A585 Windy Harbour to Skippool Improvement Scheme

TR010035

7.11 Environmental Statement Changes and Corrections Document

Version	Date	Status of Version
Rev 0	May 2019	Deadline 2 Submission
Rev 1	July 2019	Deadline 4 Submission

Status	DEADLINE 2 SUBMISSION	Revision	1
Scale	1:2500 A3	Date	MAY 2019
Drawn By	J.NORMAN	Checked By	K.BURROWS
Approved By	N.HENDERSON		
PINS No.	TR010035	FIGURE	11.4
Drawing number	HE548643-ARC-EGN-SZ_ZZ_000-DR-LE-30

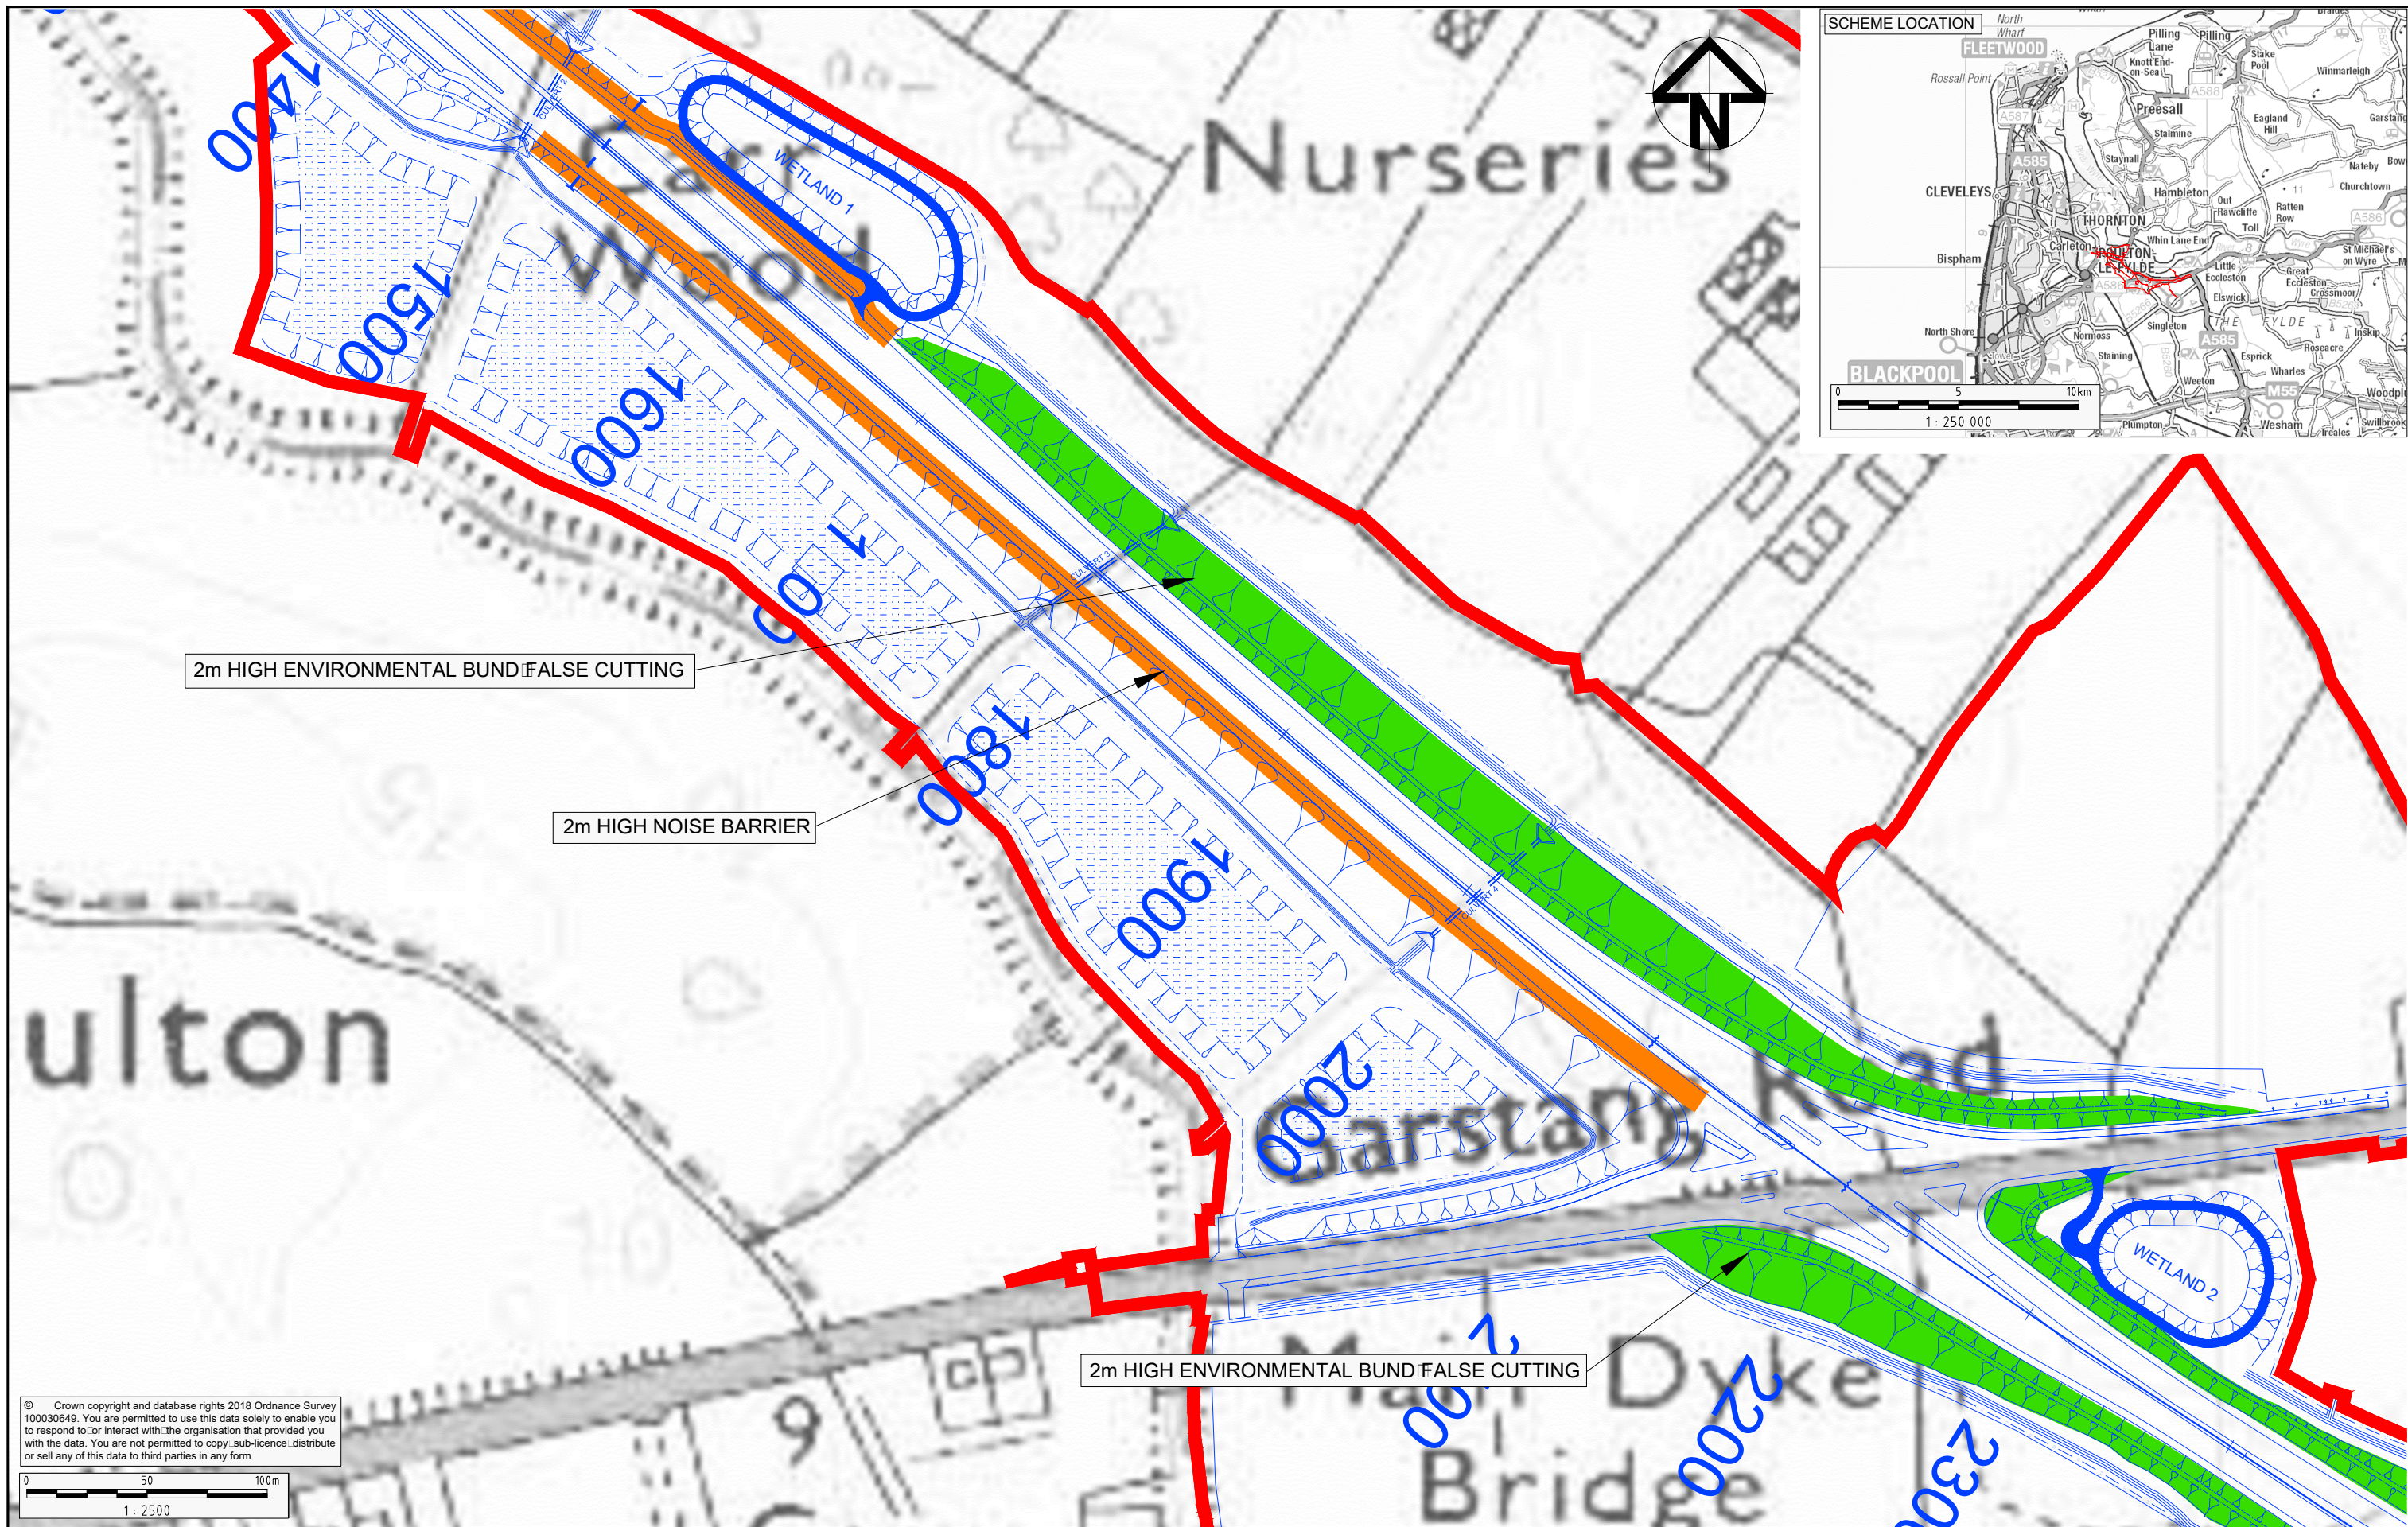
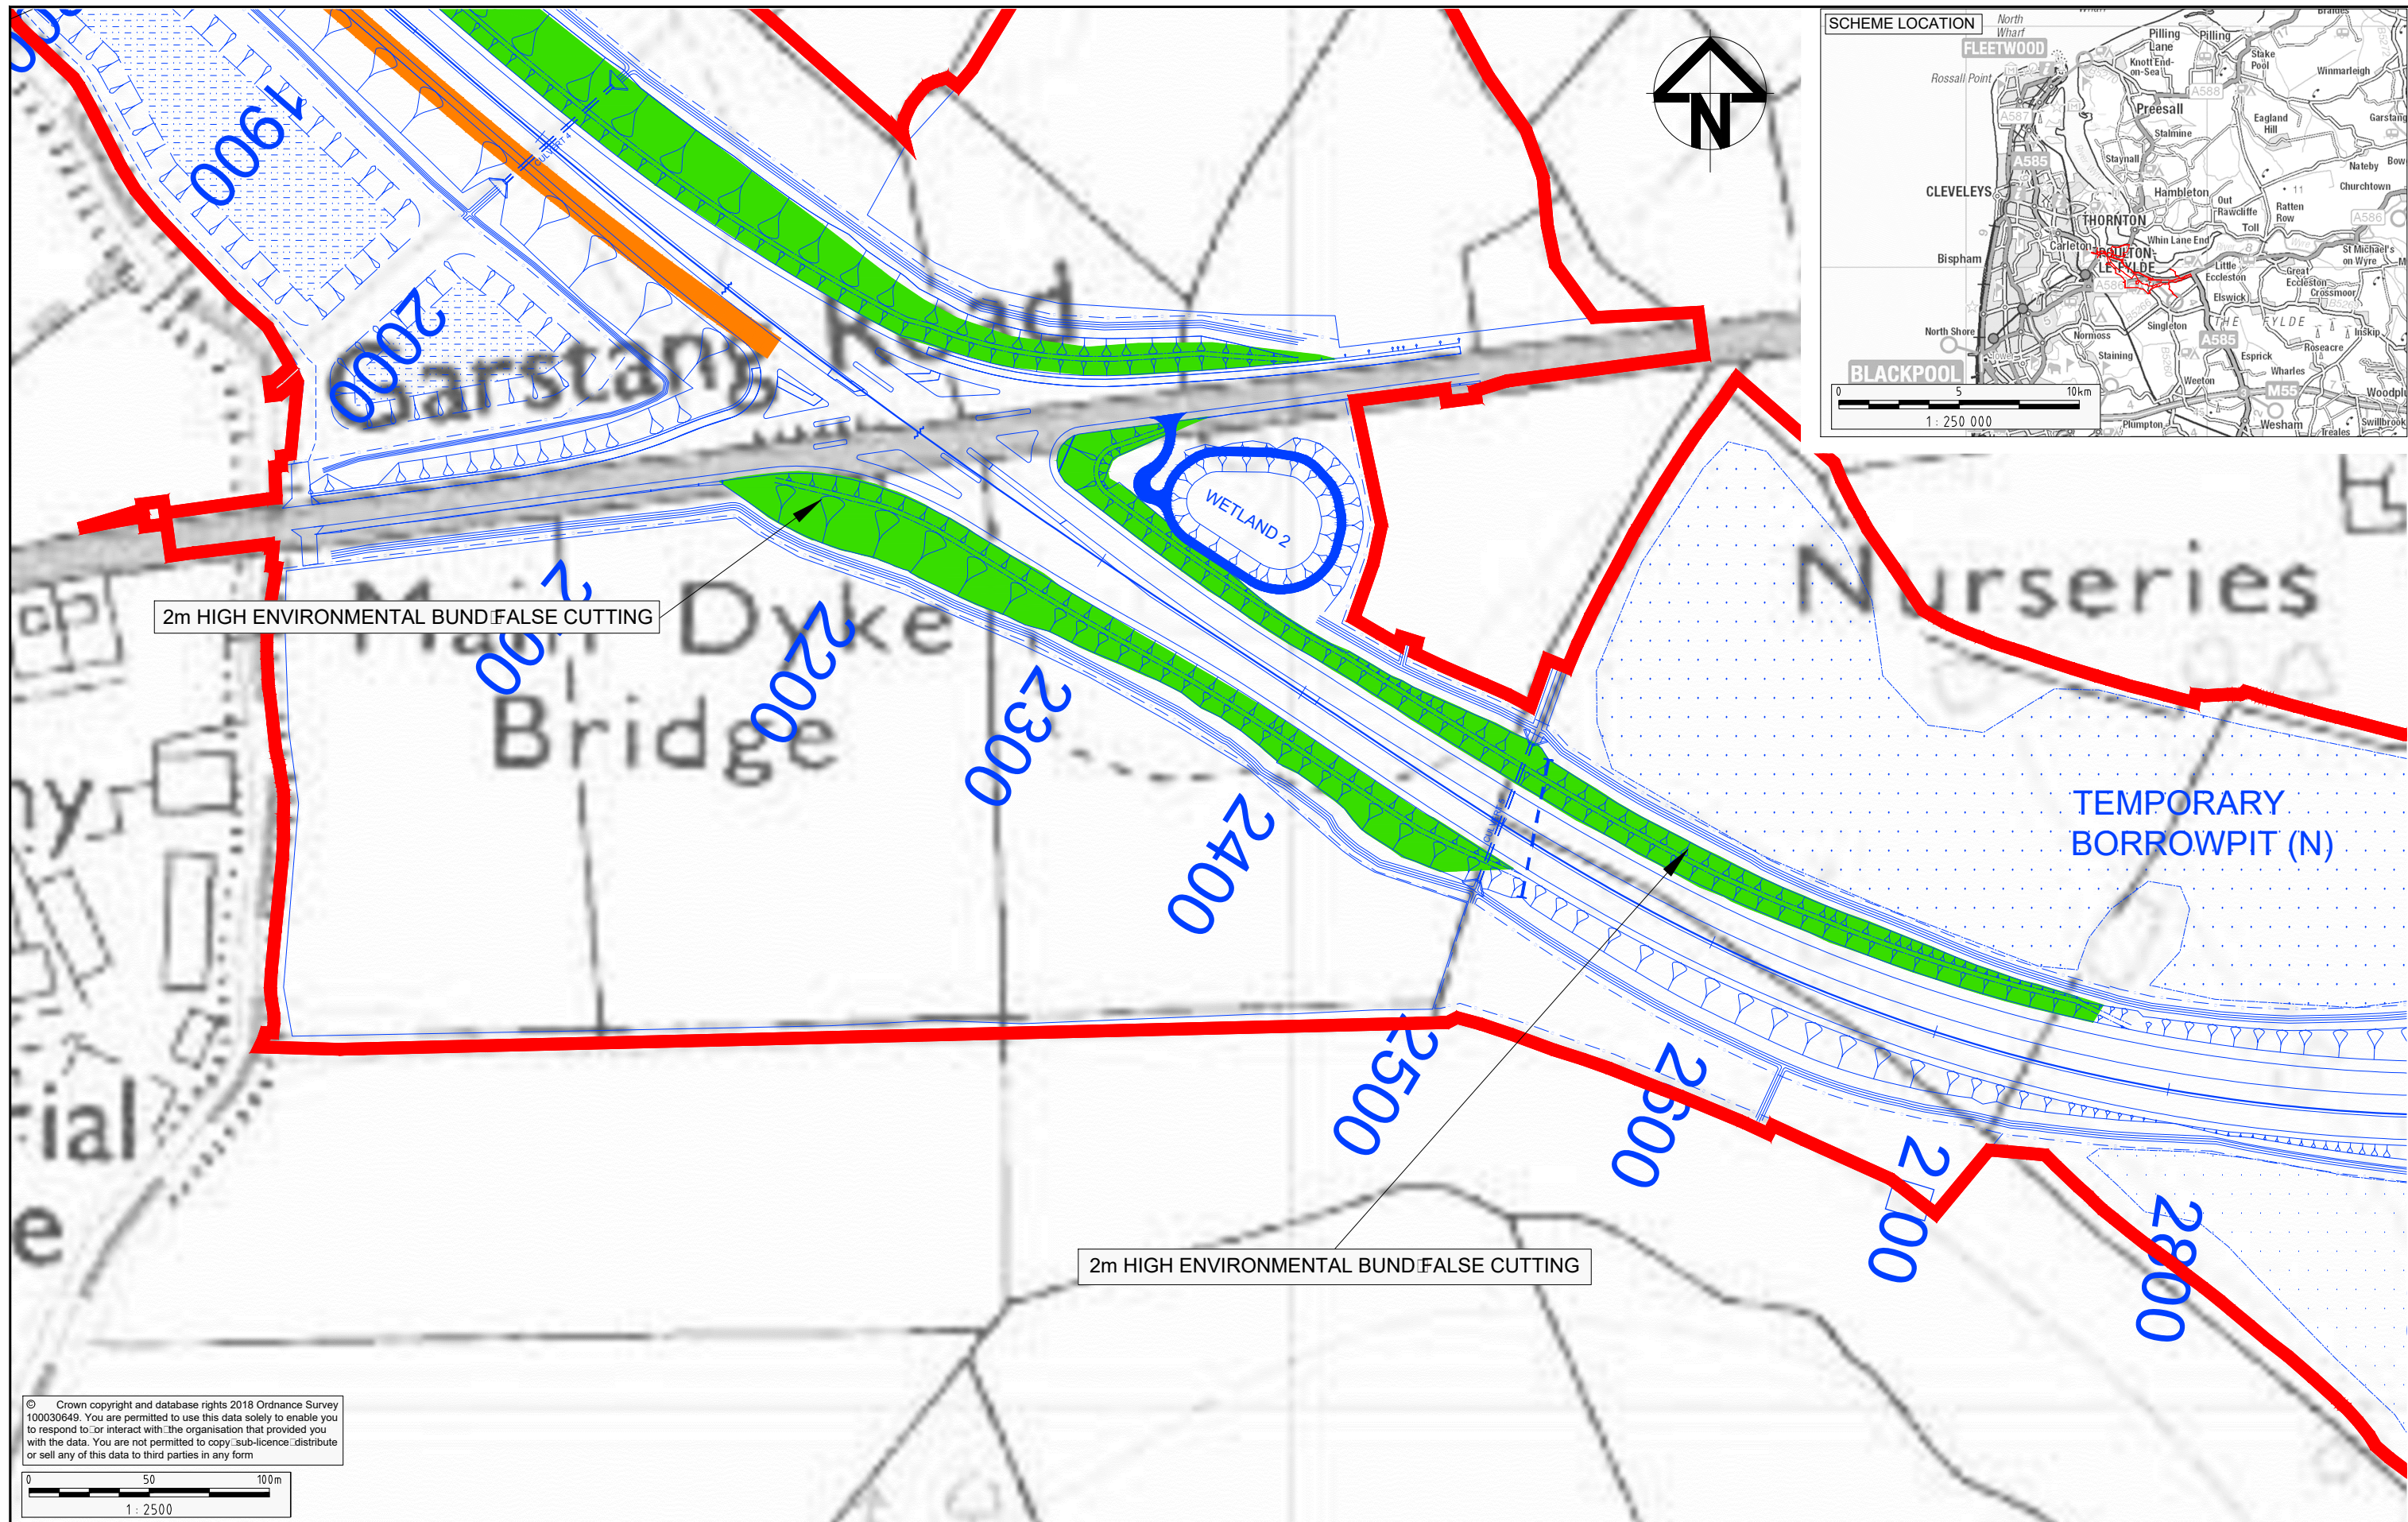
Document Reference Number	Document Name	Amendment Required	Reason
			TR010035/APP/7.10).
6.11	ES Chapter 11: Noise and Vibration	Update to Figure 11.4: Noise and Vibration – Noise Mitigation within the Study Area presented at Appendix D to show heights and locations of earth mounds and acoustic fencing at a larger scale.	Requested by the Inspector within the first round of written questions (document reference TR010035/APP/7.10).
